From: Doug Larkam [REDACTED]
Sent: 04 July 2018 13:01
To: Zac Denton
Subject: Your Ref: EP/83/18/HH

Subject: RE: Objection to our planning application - 61 Roundstone Crescent

Project: Proposed extension; 61 Rounstone Crescent, East Preston BN16 1DQ	
Drawing: Plans and elevations as proposed	
For: Mr. & Mrs. D. Larkham	
Drawn: PKS	Date: April 2018
Scales: 1:100 1:200	No: 2279/01/02
To scale when printed on A3

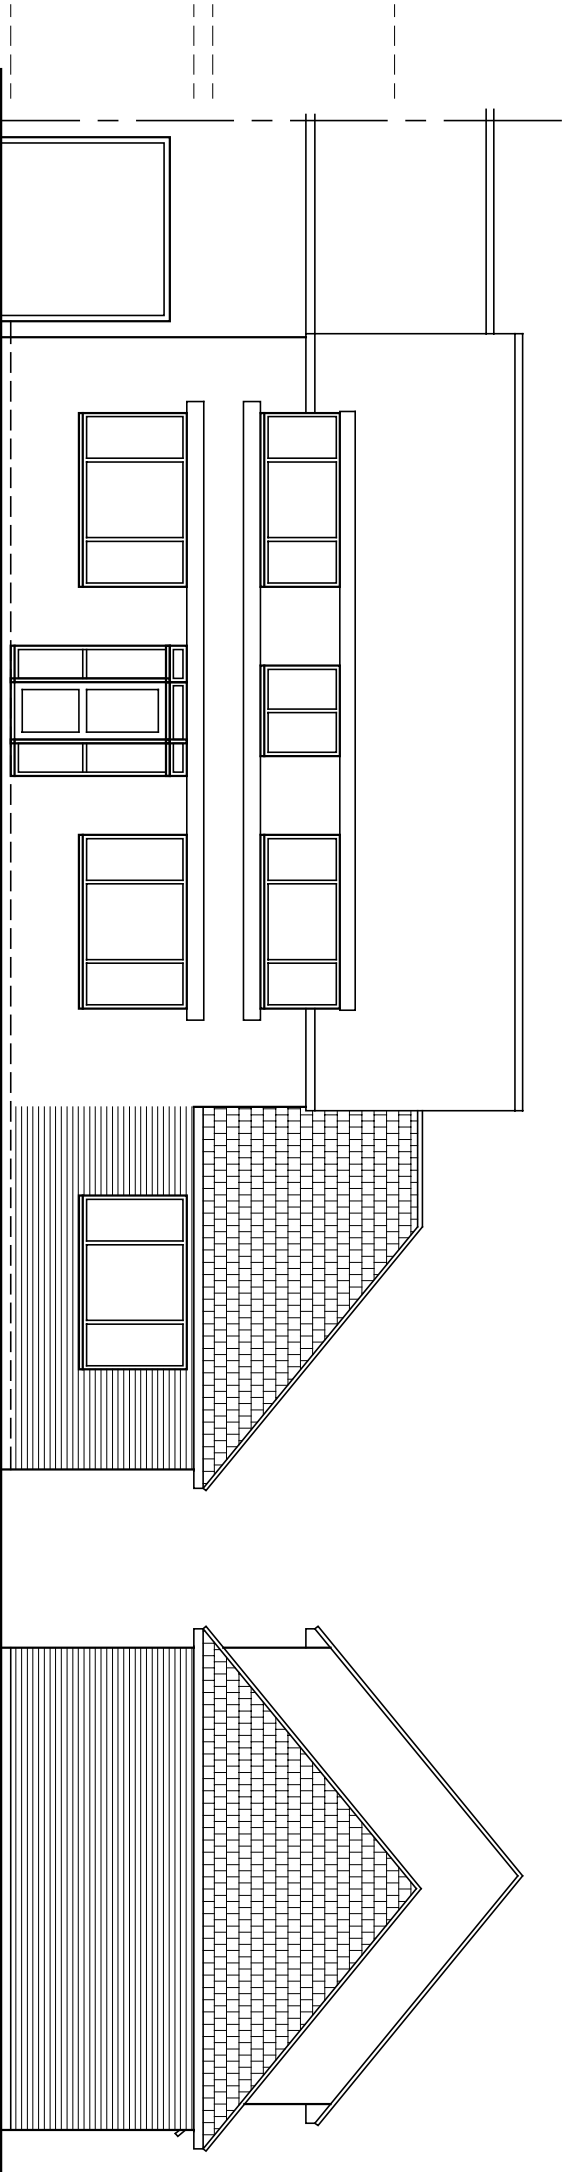
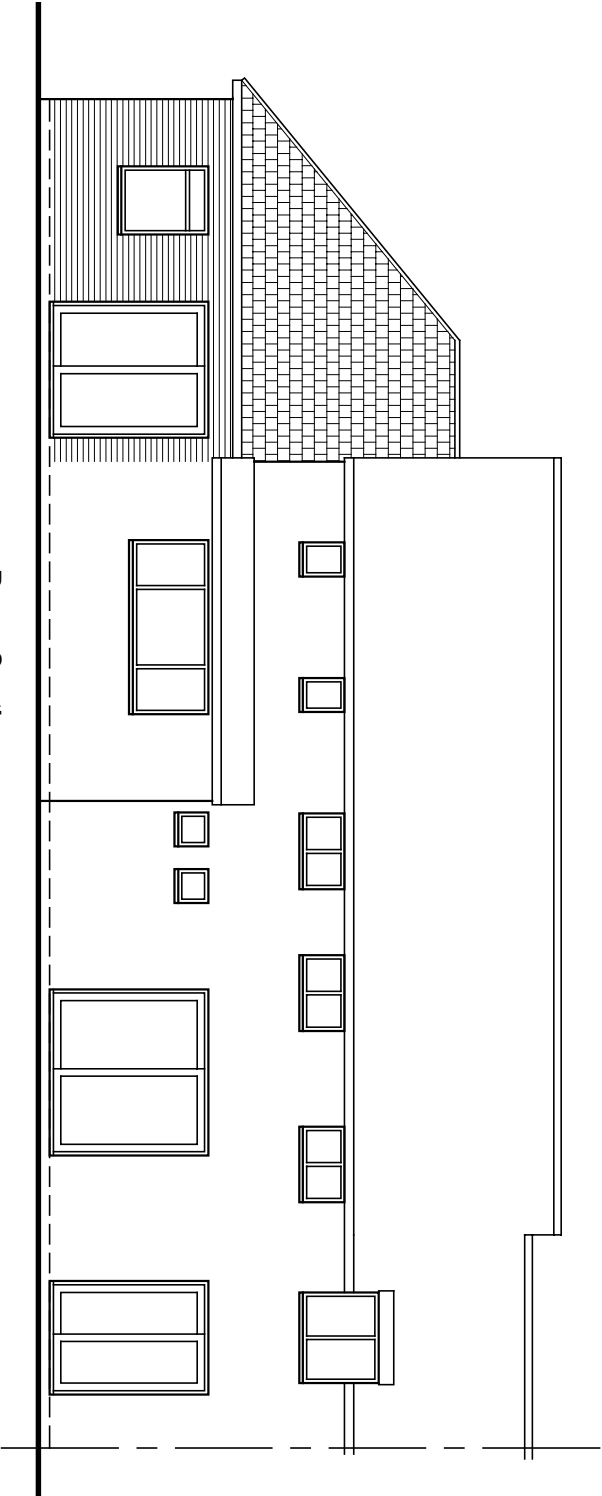
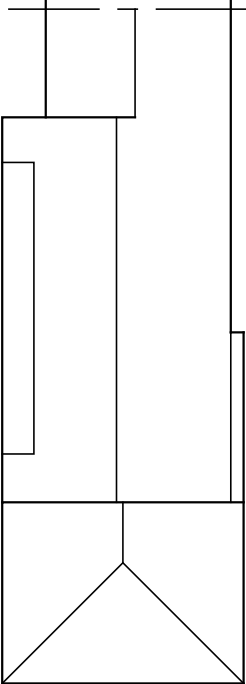
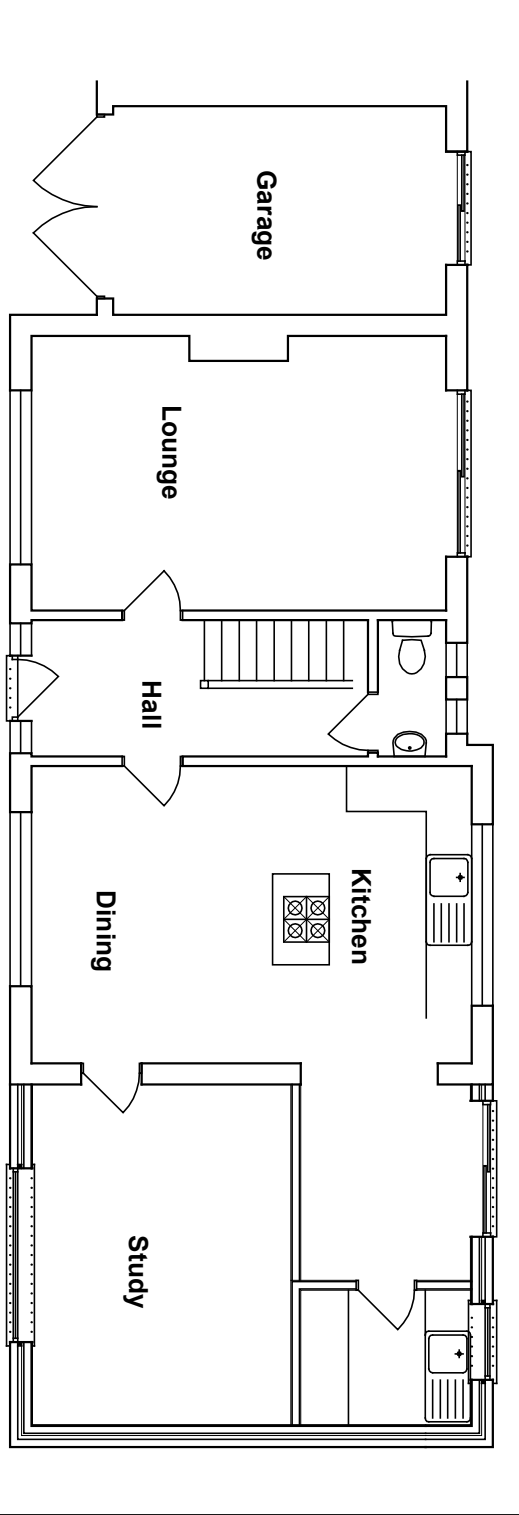
You have understood correctly, as this council is a statutory consultee on a range of Planning Applications, this council's Planning & Licensing Committee considered your Planning Application at its meeting on 25th June, agreed it would raise an objection only to the size of roof and submitted that objection to Arun District Council.

I attach the draft Minutes from the meeting. As you will see it was to the size of proposed roof the committee objected. This is as stated in the letter of objection submitted to Arun. I think the committee would be happy with a lower ridge height but only the committee could confirm that if a revised drawing was presented. There is no guarantee Arun will agree with the comments we have submitted.
